I am writing as a parent of a child that attends Darlington Public School regarding the proposed development by the University of Sydney, MP 07_0158 – Abercrombie Street Precinct, Syd Uni. Darlington Public School is an inner city school servicing the suburbs of Chippendale, Darlington and parts of Redfern. The school is directly adjacent to the western border of the project.

SITE PLAN

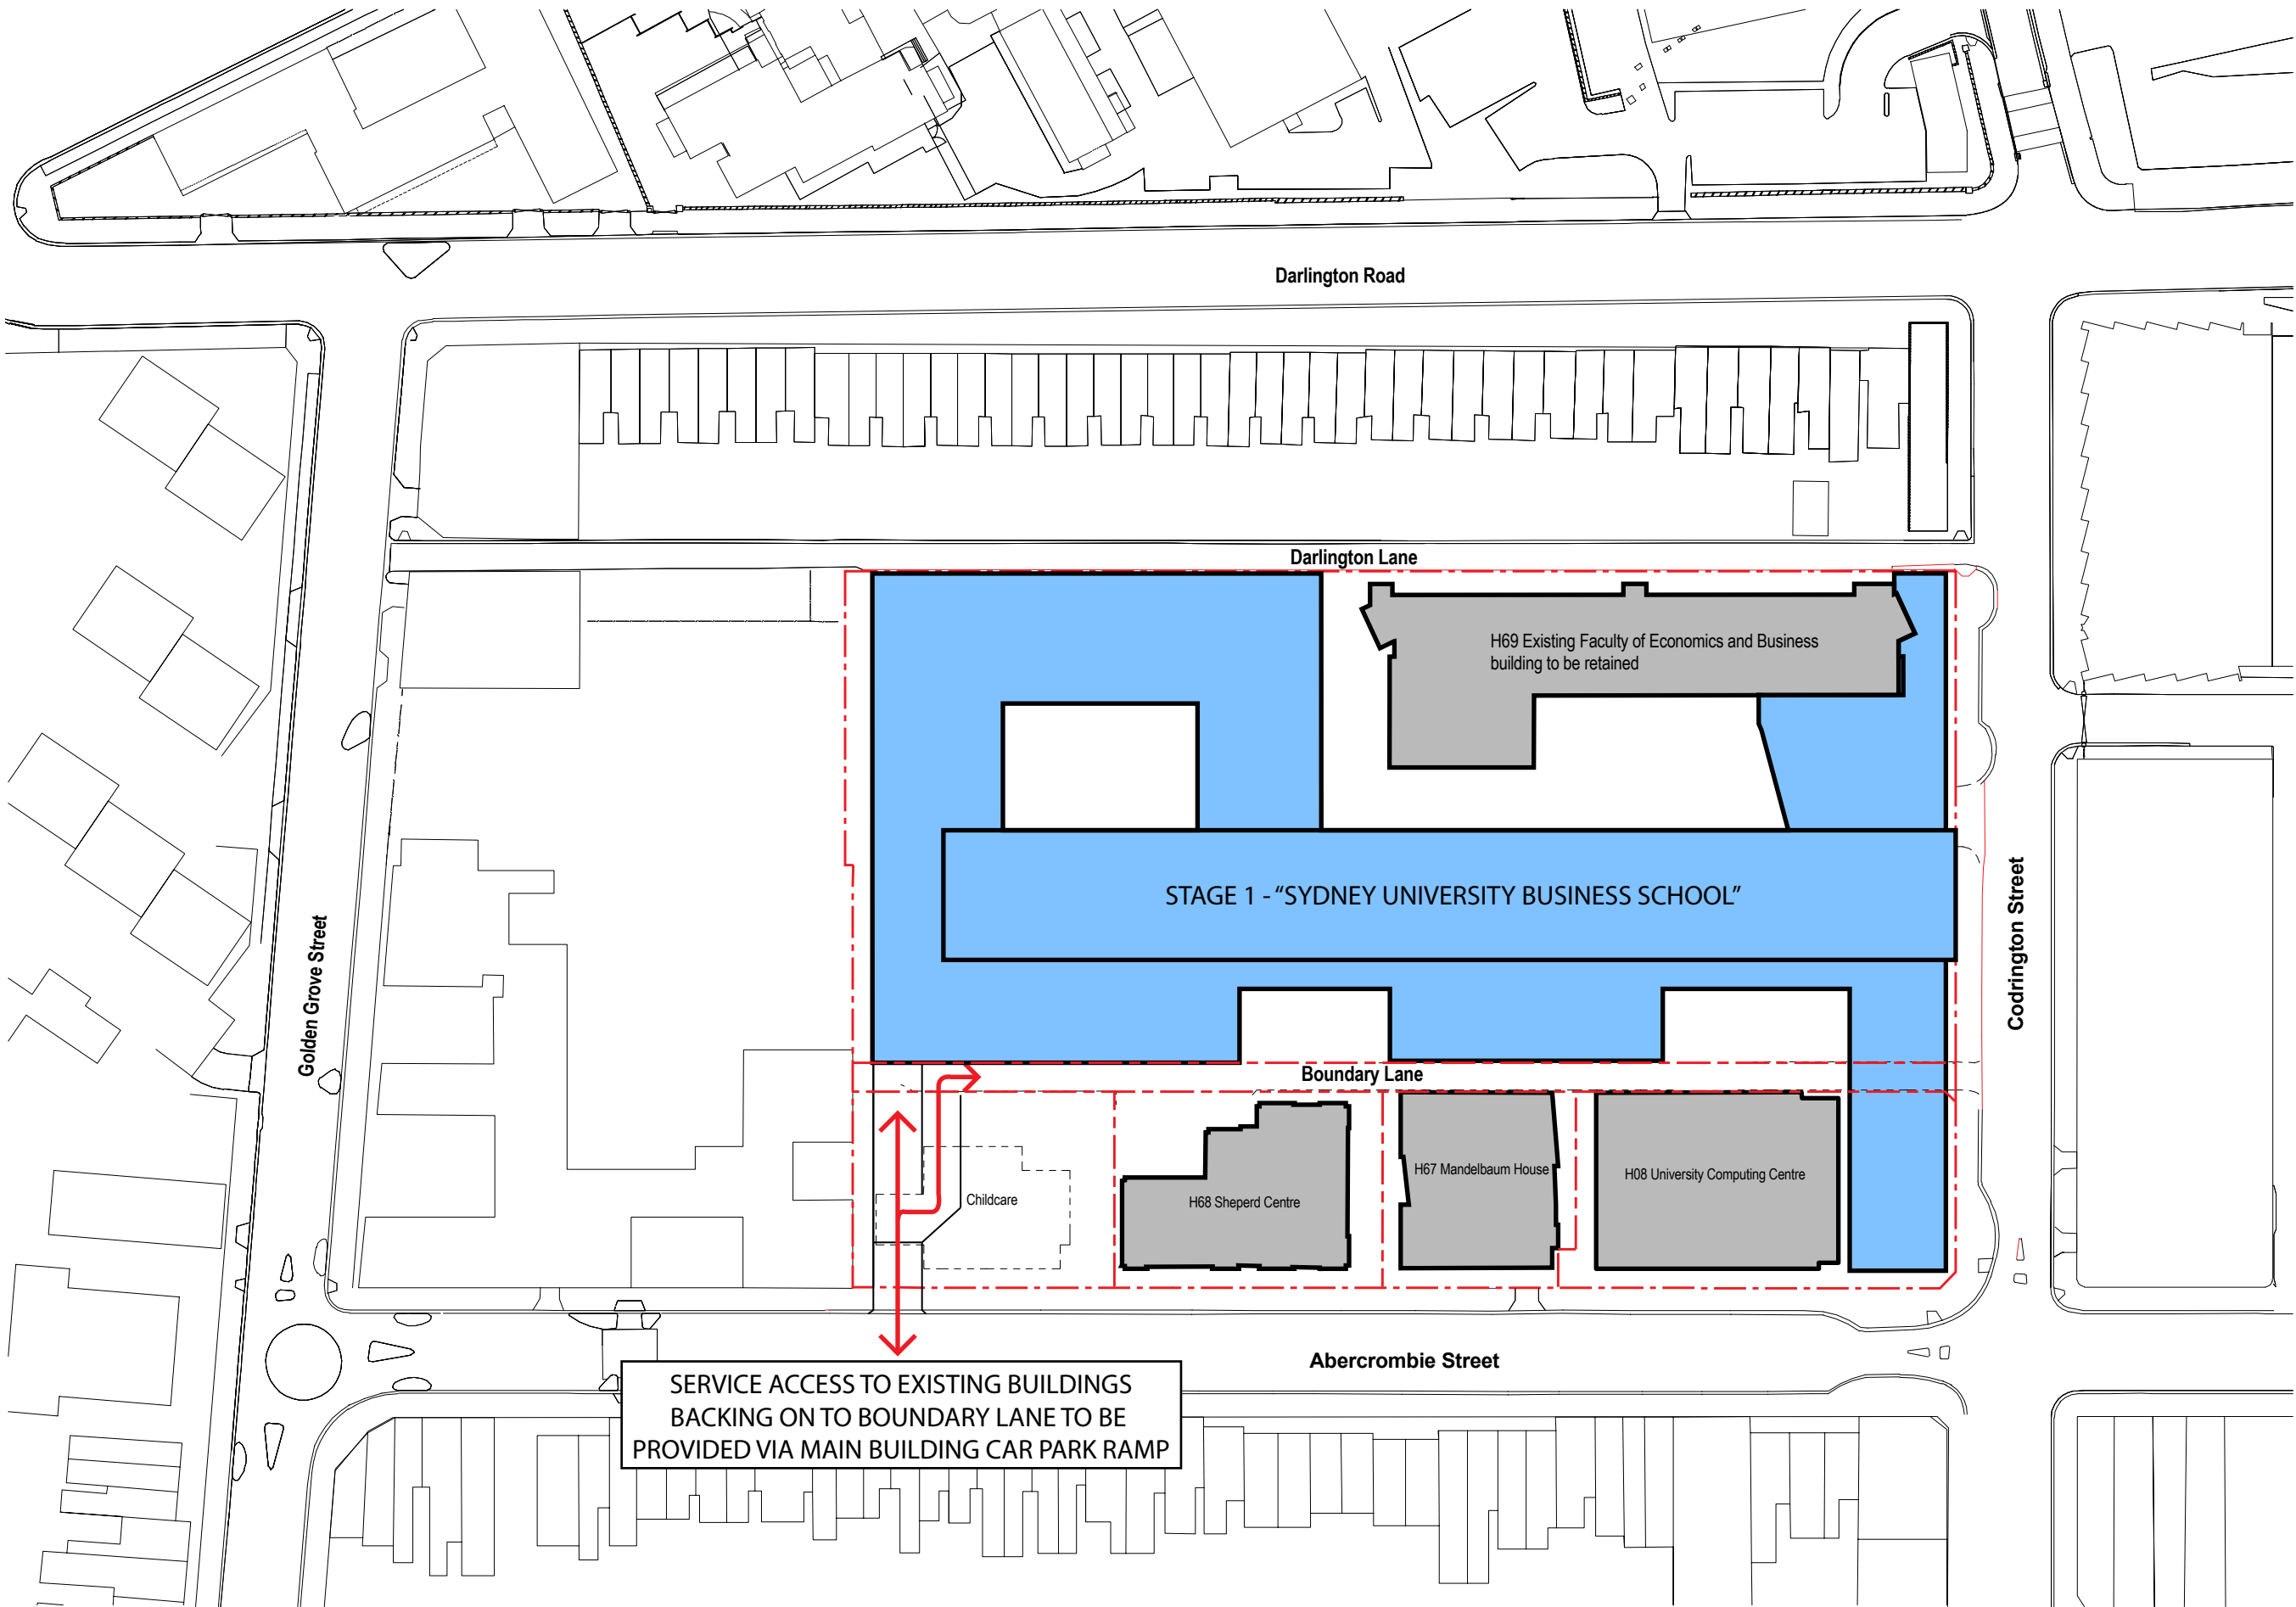
The proposed access point for the site is on Abercrombie Street and is directly adjacent to the school classrooms on their North East border of the school site. Locating the access point for trucks would:

- produce unacceptable levels of noise and vibration in the school classrooms that border that entrance – year 2, 4, 6 and both kindergarten classes. This is also particularly significant for the 2 kindergarten classrooms which face the development to the north with only glass panels and glass doors on that side.
- create an unsafe corridor for school children and parents that walk, or ride to school along Abercrombie Street (north side). This includes many unaccompanied but young children entering and leaving the school.
- create an unsafe car drop off and pick up point on Abercrombie Street (the main drop off point at the school).
- reduce the drop off and pick up point area for numerous children who are transported by car.

Proposing an entry point in Abercrombie Street will force trucks and plant to be transported through residential and school areas to the project site. The more direct route is from City Road to Codrington Street and will allow access directly into the project site without passing through residential areas or the proposed access that is within metres of classrooms, or across the footpaths and pedestrian crossing that children use to access the school.

| As per the current development plan, the proposal calls for an underground car park to be built for the student accommodation and University staff. The car park will accommodate 18⁵ car spots, and its entrance will be on Abercrombie Street, at approximately the same point of the construction access.

The concerns raised above about the access point to the construction site are the same for this car park access point increasing the risk to school children's safety, in an area that has already been highlighted through the respective organisations (Council, Police, and RTA). The increased traffic flows and access point are an unacceptable risk to the children who attend the school. There is no justification for this level of risk to a school community, particularly as the University has another street frontage without school or residential issues (the University being the only stakeholder for Codrington Street) and an access street internal to project (Darlington Lane)._
